Our Case Number: ACP-323980-25

Re: Proposed Water Supply Project for the Eastern and Midlands Region
in the counties of Clare, Limerick, Tipperary, Offaly, Kildare, and Dublin.

Re: Proposed Water Supply Project for the Eastern and Midland Regions
Case Reference Number 323980

Drawing Title	WATER SUPPLY PROJECT EASTERN AND MIDLANDS REGION						
Drawing Title	Figure 4.67 BREAK PRESSURE TANK ACCESS ROAD						
Drawing Status	FINAL - PLANNING APPLICATION						
Jacobs Tobin No.	32105801	Client No.	9318				
Drawing No.	32105801-700-06103

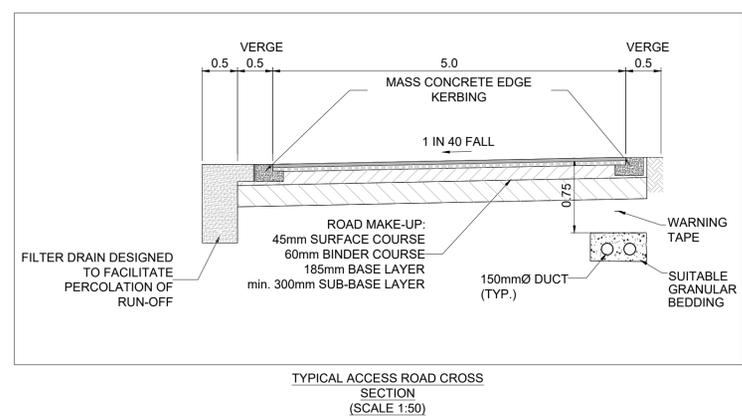
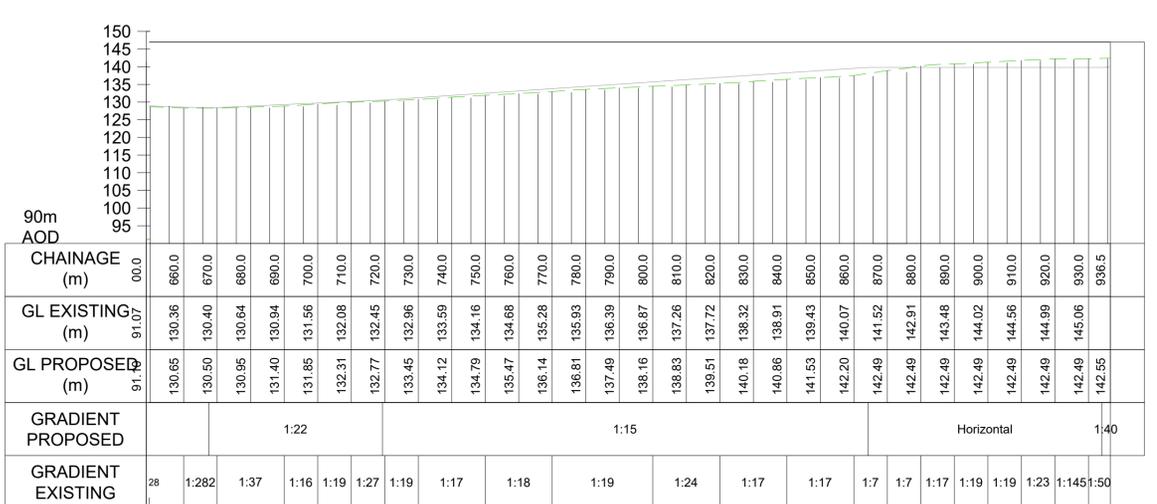
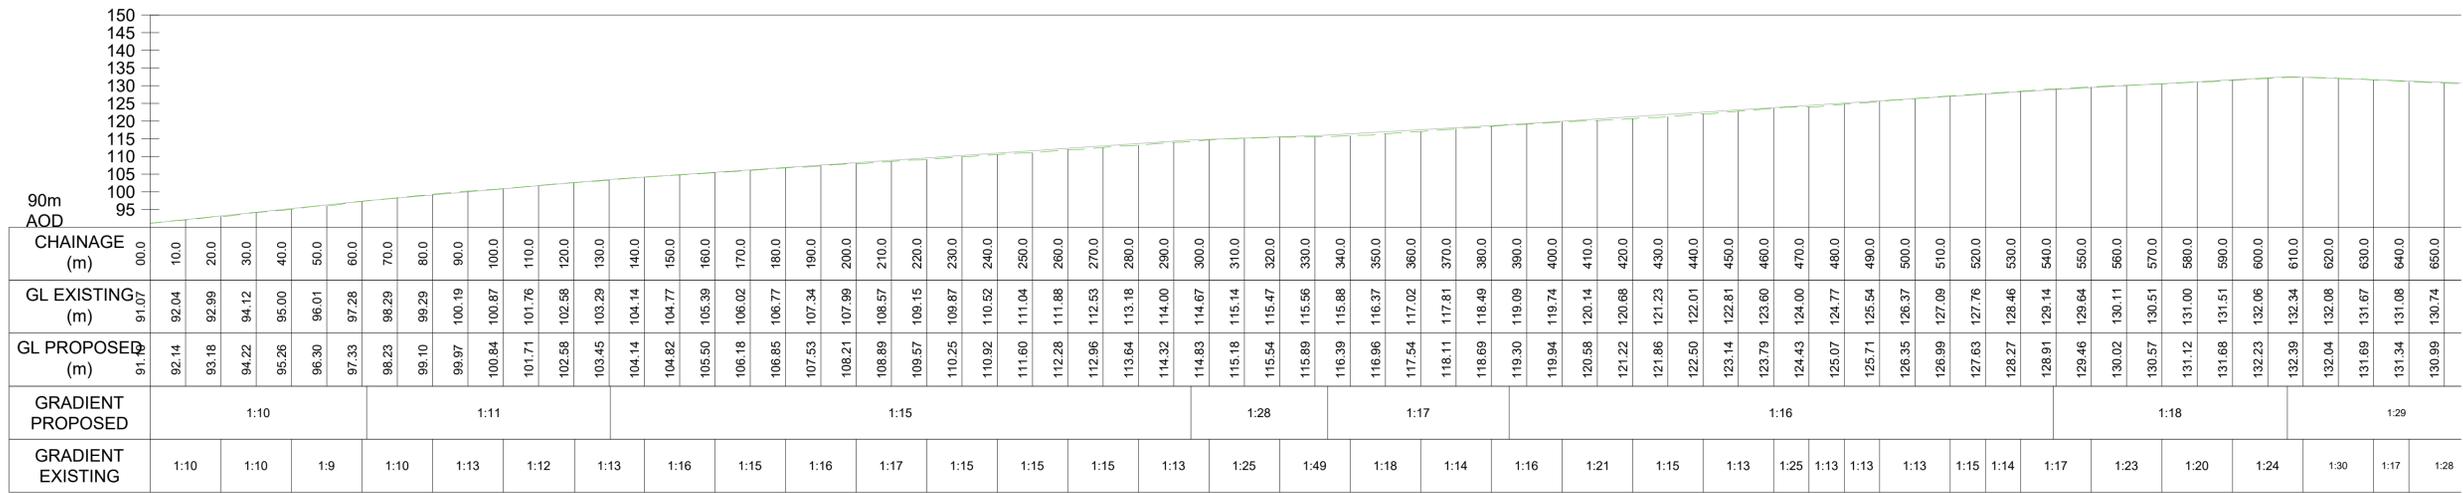
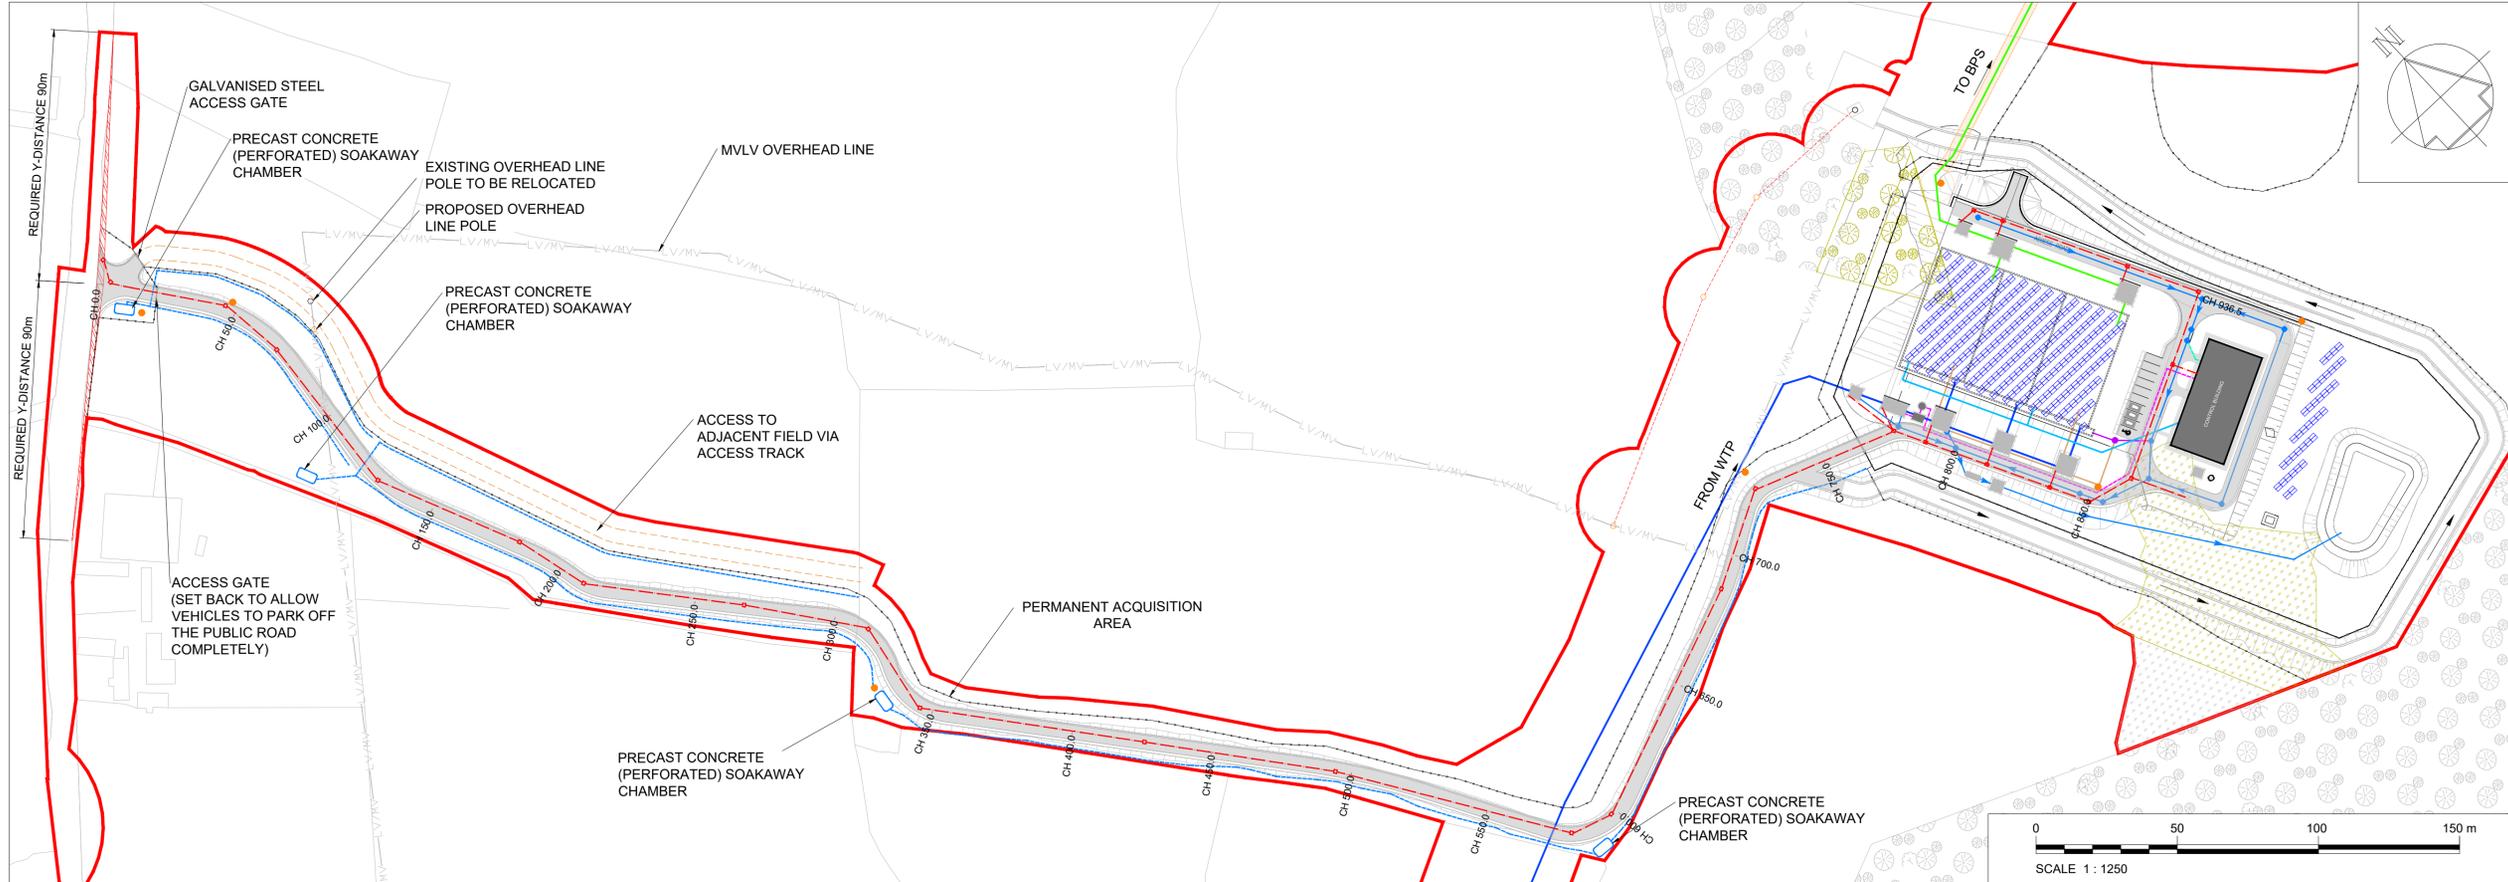
The reason for the Break pressure Tank (BPT) was originally stated to save energy. The response acknowledges that pumping water to a high point would use more energy than is saved.

The response now states that the BPT is needed for safety reasons relating to control and transient pressures.

This statement ignores the development of variable speed drive electric motors and control systems over the past 40 years.

The main causes of transient pressure surges are,

- Sudden pump starting/ stopping, this is eliminated by variable speed drive electric motors and flywheels on the pumps.
- Sudden valve closure, this is much less likely with full bore ball valves than butterfly valves. In any case the surge is not reduced by a BPT unless the BPT is close to the valve closure.
